Tower Club/Coco Lounge
8-10 Clifton Road
Littlehampton
West Sussex
BN17 5AS

Our Ref: LU/264/18/PL

**Town & Country Planning Act 1990 (as amended)
Town and Country Planning (Development Management Procedure) (England) Order 2015
Application for Full Planning Permission**

Development Change of use from redundant function room to office.
Location 8 - 10 Clifton Road Littlehampton

PROPOSED FIRST FLOOR OFFICE PLAN 1:50

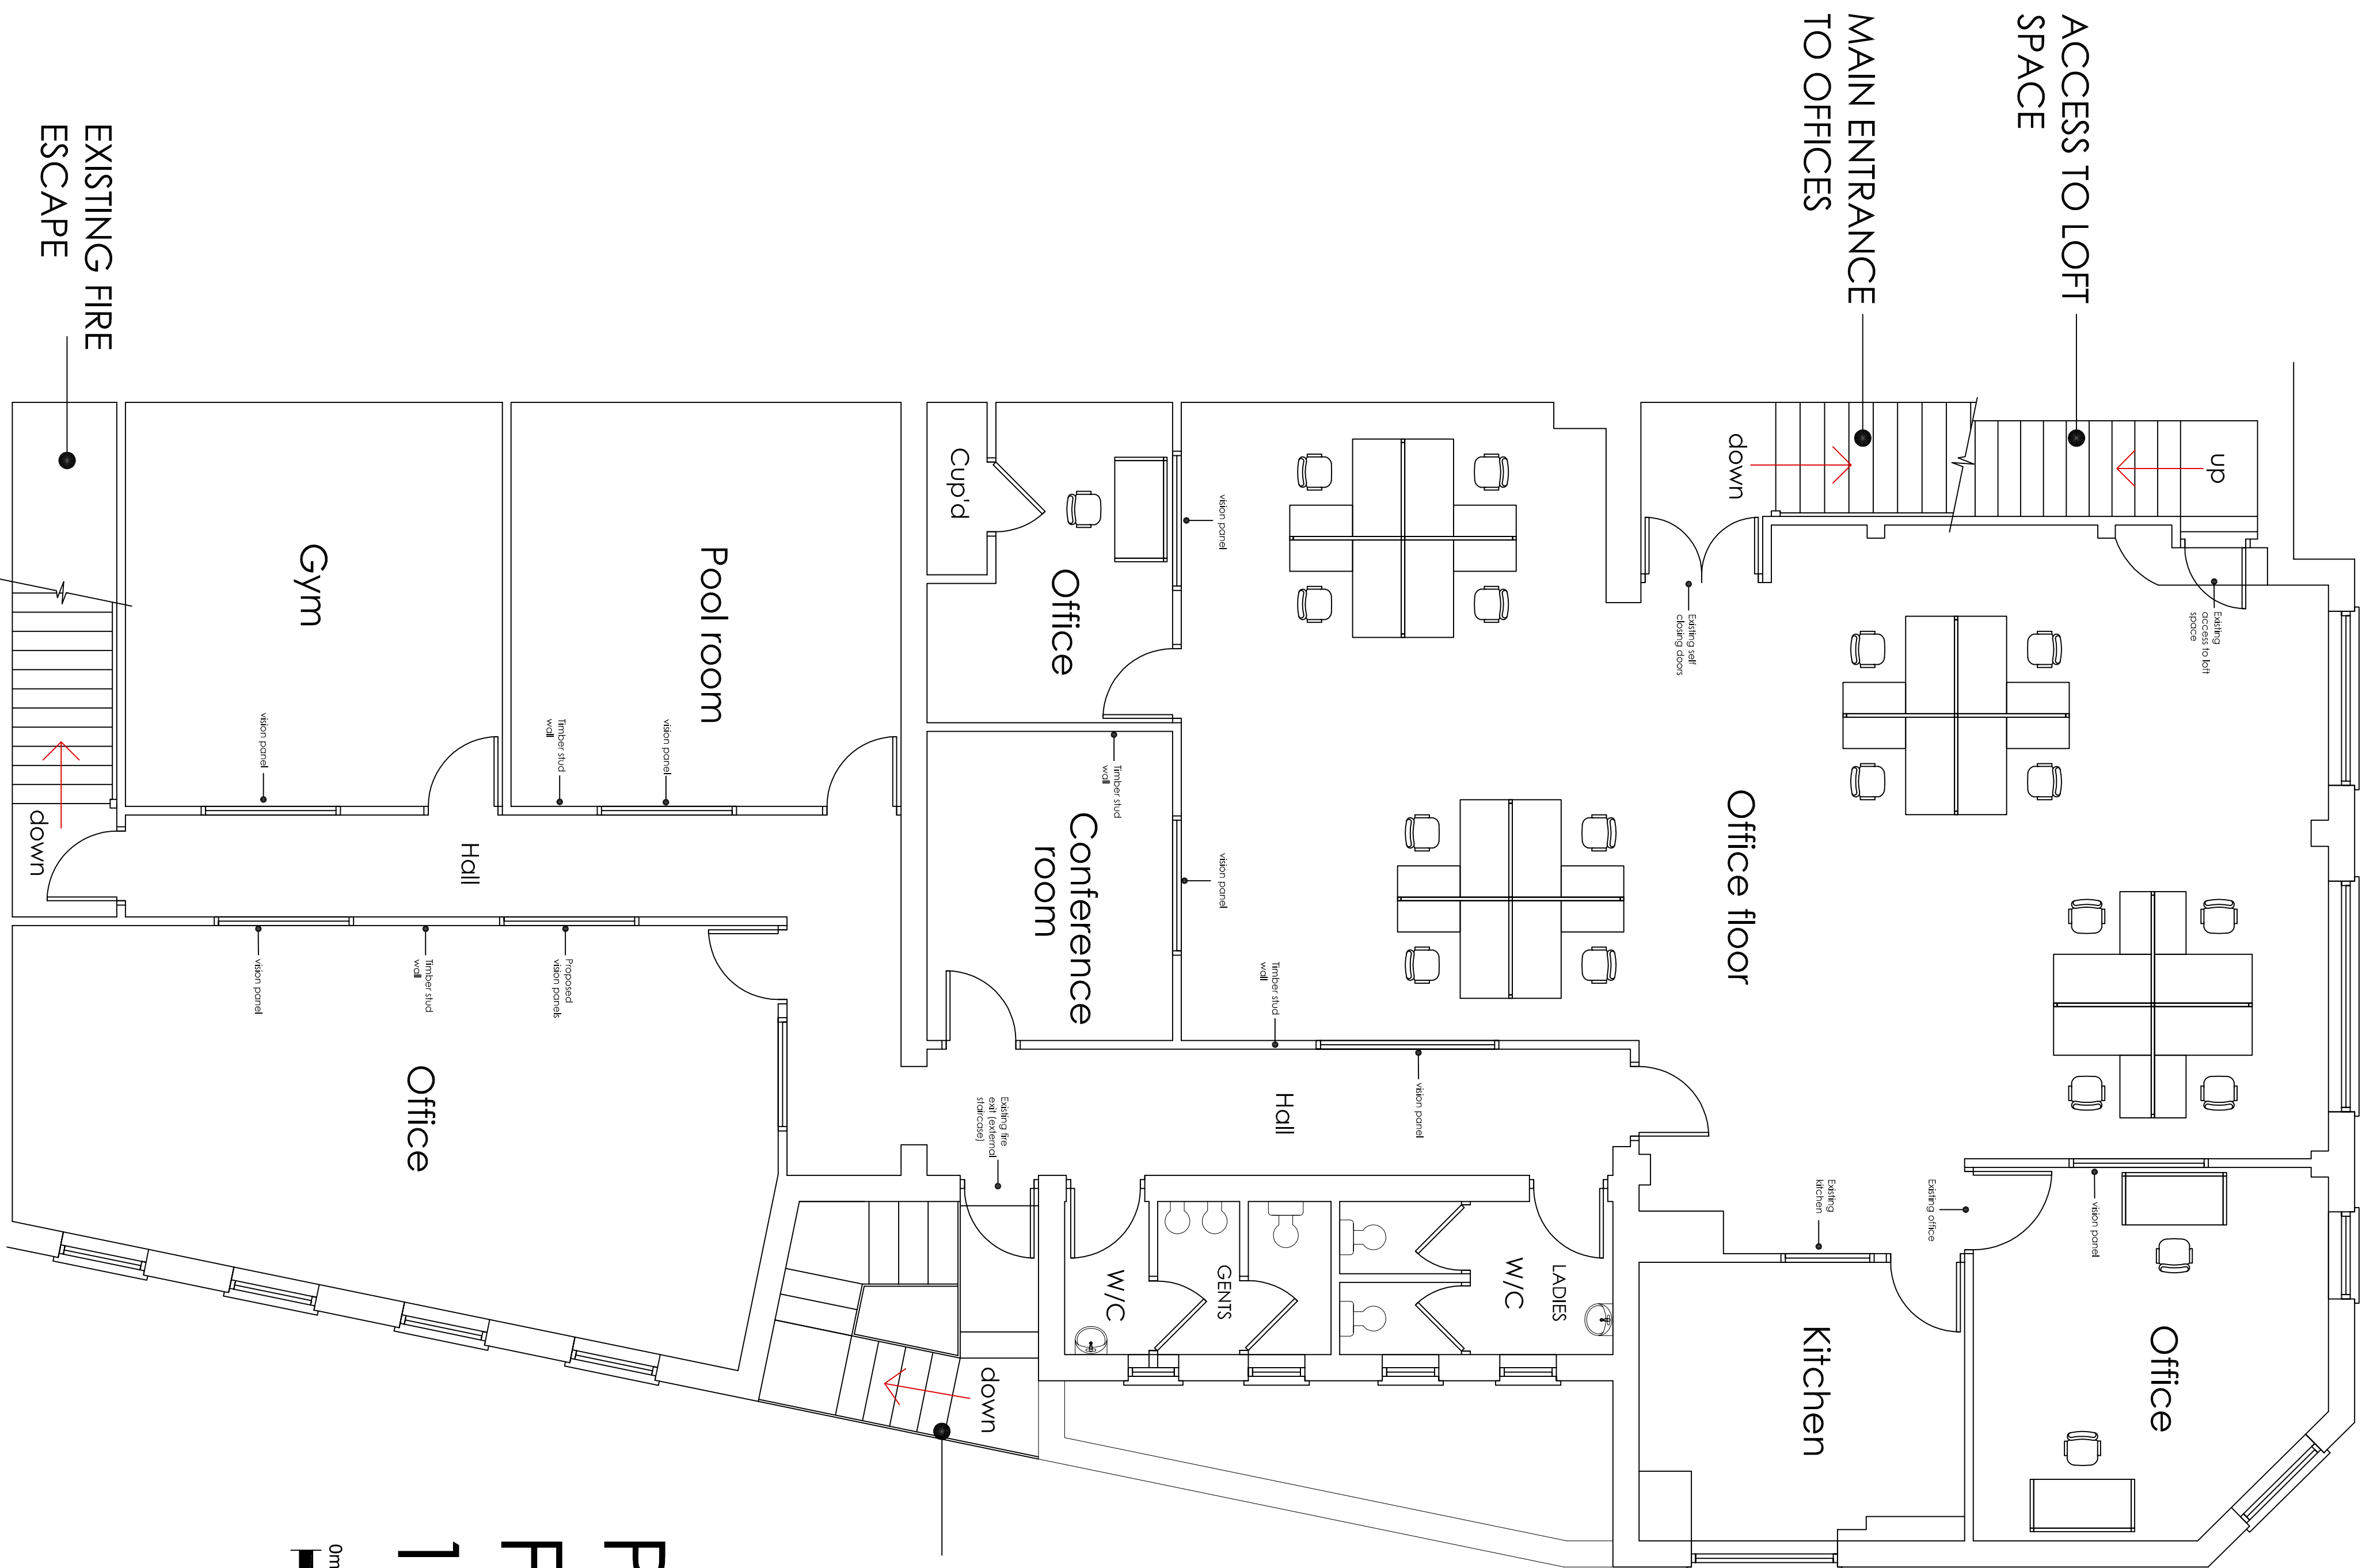
Please provide a scale for the existing and proposed floor plans (the plans that were submitted on A3 paper) and provide a scale or measurements on the plans.

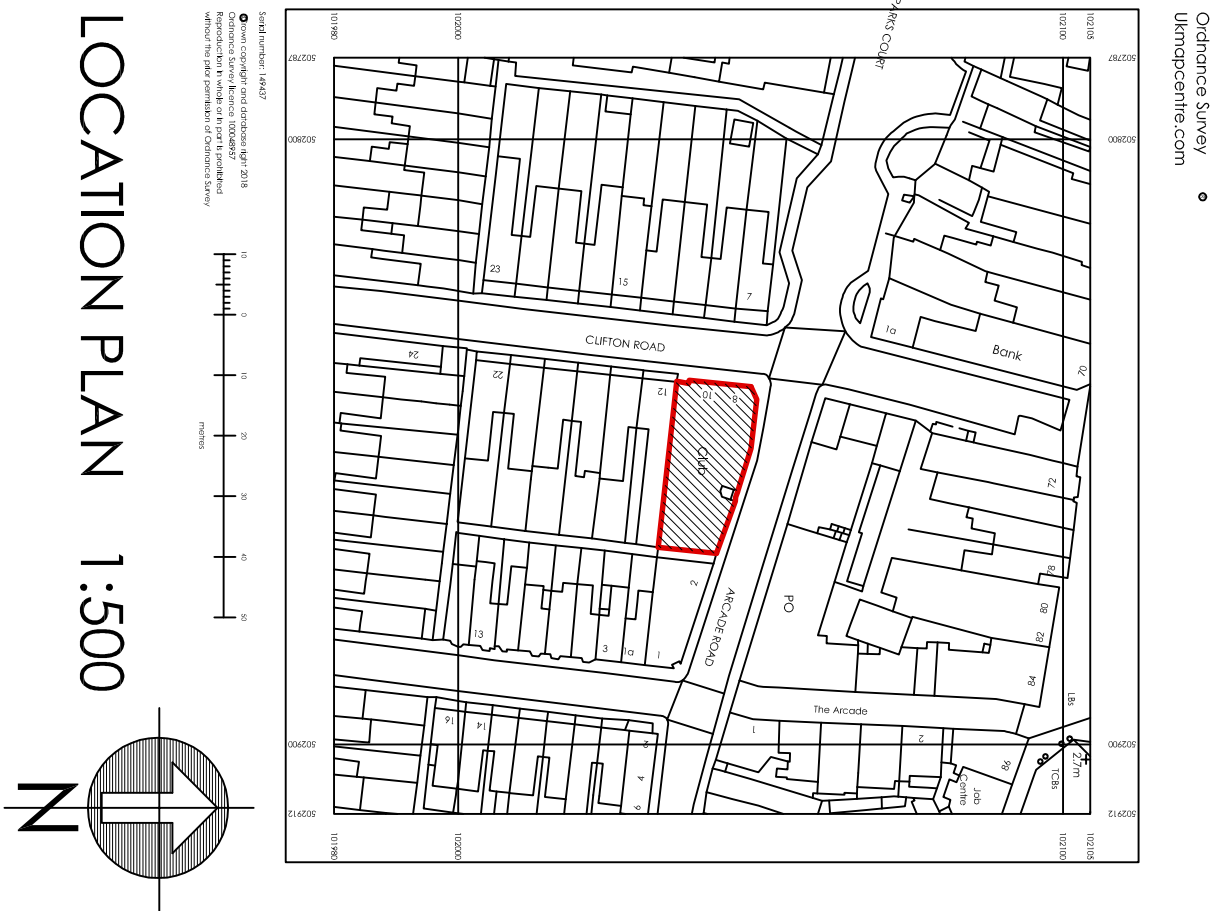
Location Plan Amend

Please red edge the application site and provide a scale.
